File No: SF17/31972
Ref No: DOC17/466091 - 4

RE: SSI 17_8256 – Sydney Metro - City & Southwest Project (Sydenham to Bankstown, T3 line upgrade) – Exhibition of EIS

Figure 98: Marrickville Station – indicative layout of key design elements

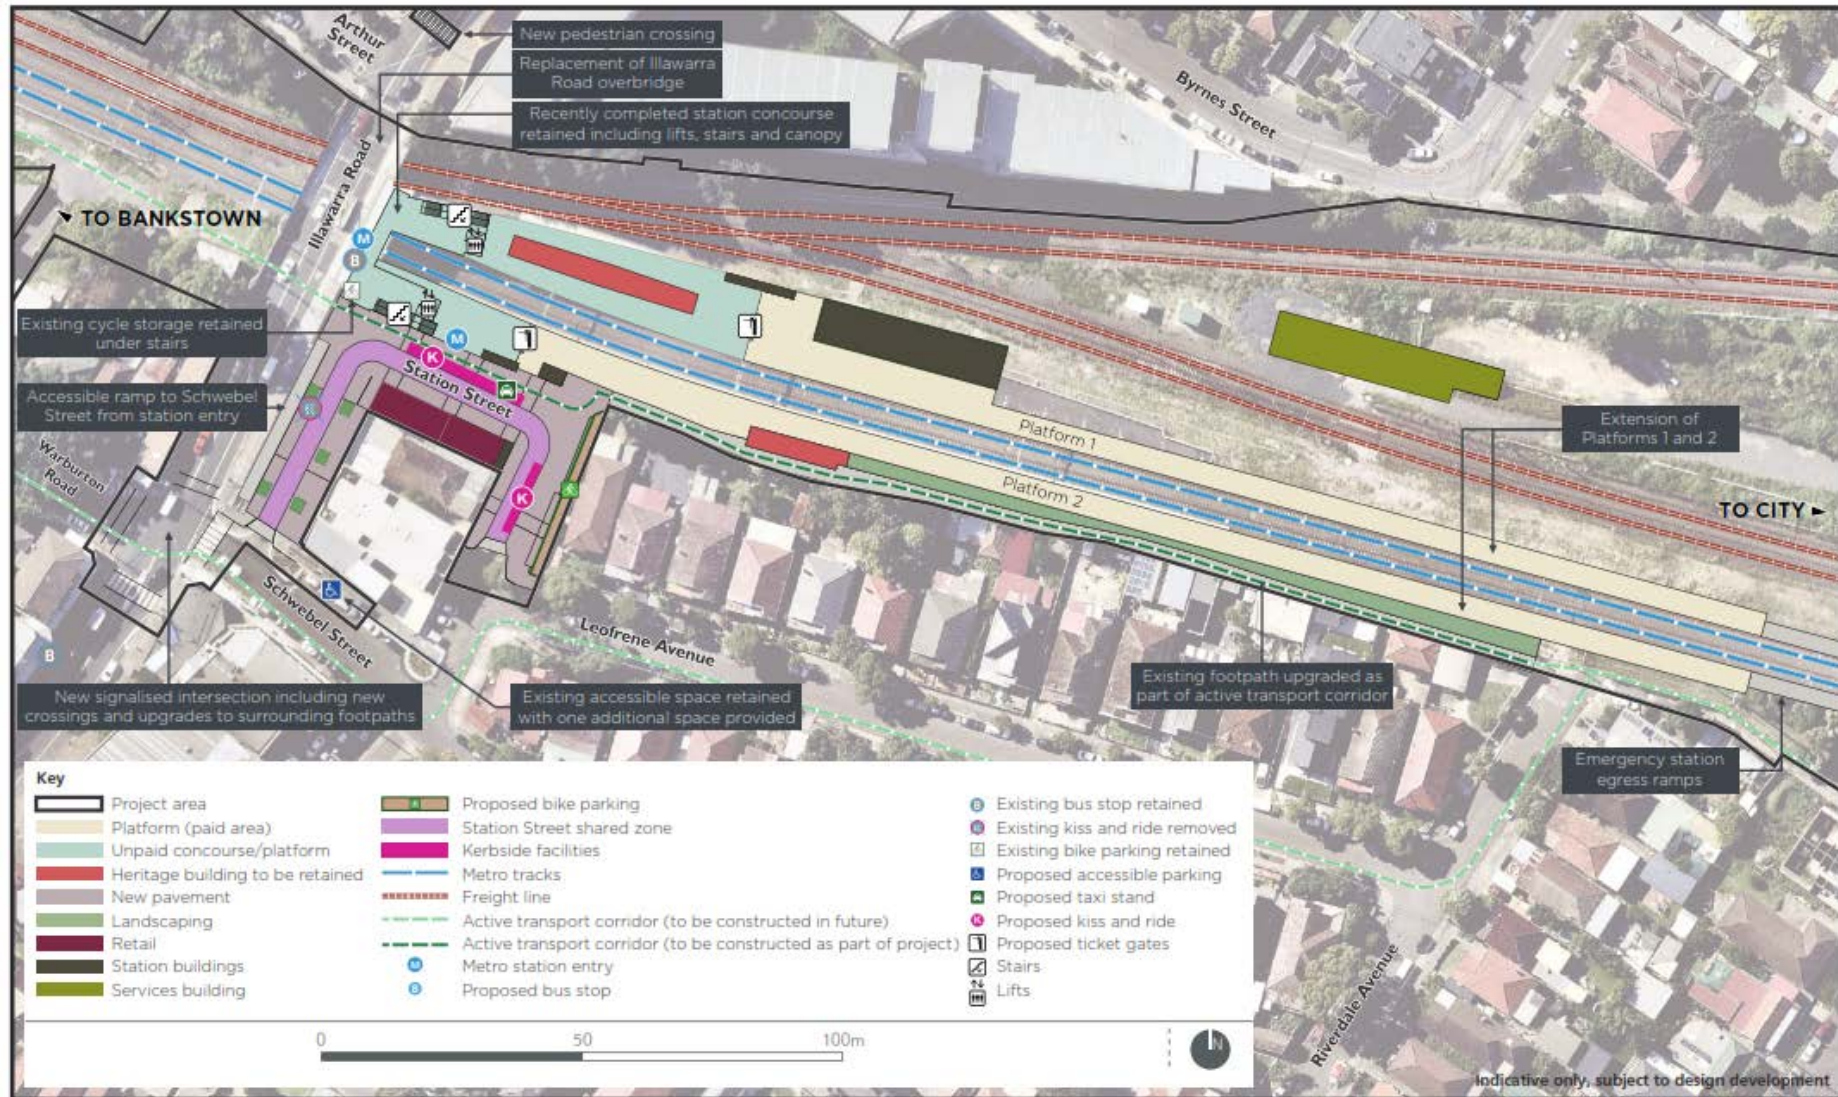
- At Marrickville Station, existing platforms would be straightened and extended to the east and heritage station buildings on platforms 1 and 2 would be retained. The major impact involves the replacement of the existing Illawarra Road overbridge which is an item in the SHR Group.
- The heritage assessment describes a 'moderate impact' to Canterbury and Belmore railway station groups (both listed on the SHR). For Canterbury, this may be an under-assessment given that the heritage listed footbridge and overhead booking office would be removed and the brick platforms would be rebuilt and extended. It is noted that the footbridge was modified in the 1940s and the booking office was rebuilt in the 1980s. The heritage assessment argues that the most significant buildings within the Listed Group – the Platform buildings - would be

- Significant fabric of the platforms and station buildings that are to be demolished must be carefully dismantled and stored safely in accordance with fabric and salvage strategies for future reassembly and potential reuse in interpretation.

Figure 104: Canterbury Station – indicative layout of key design elements

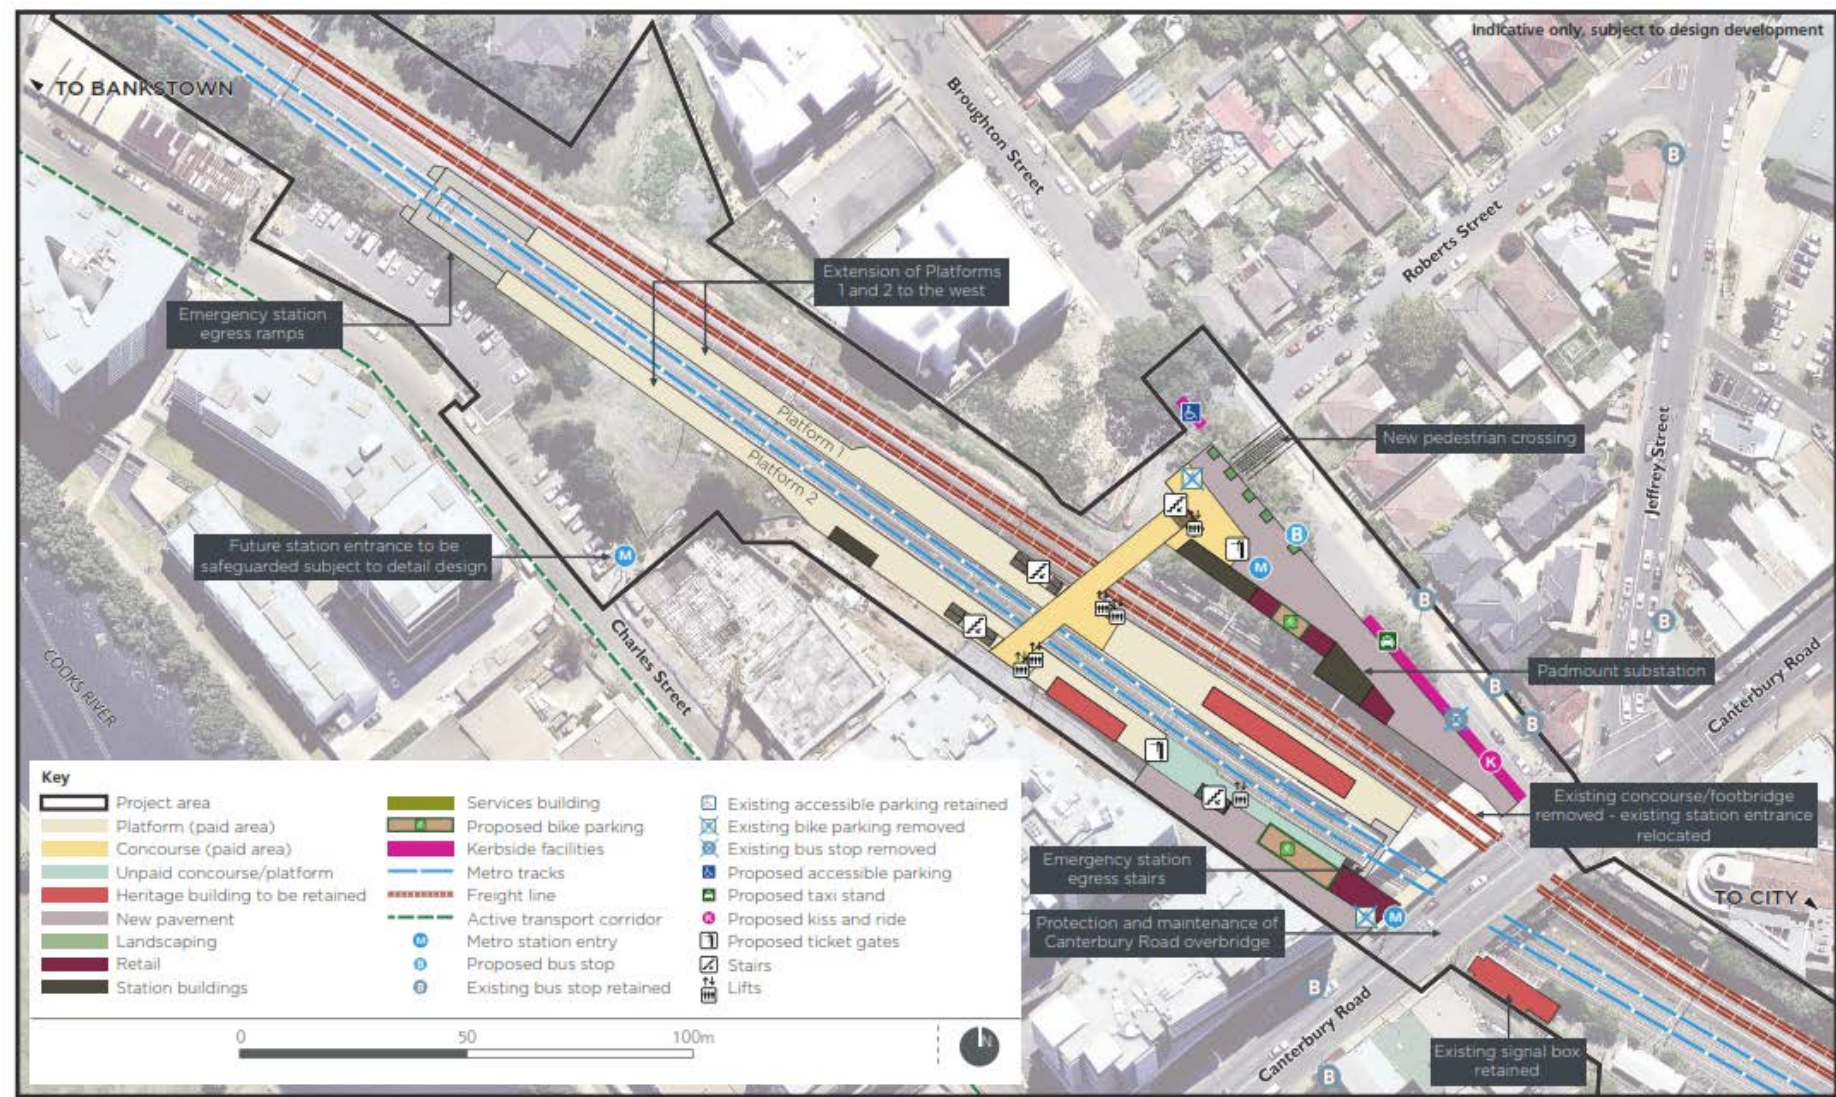
These initiatives are supported by the Heritage Council of NSW. It is considered that new design should respect and celebrate the heritage and sense of place. There should be local character reflected in the differences between individual stations with consideration being given to form, fabric and materiality. Whilst it is positive that heritage items are to be retained, it is important that all opportunities for adaptive reuse of station buildings are pursued as part of this project, rather than the creation of further redundant station buildings. Canterbury signal box is a particularly significant item for which an adaptive reuse should be found.
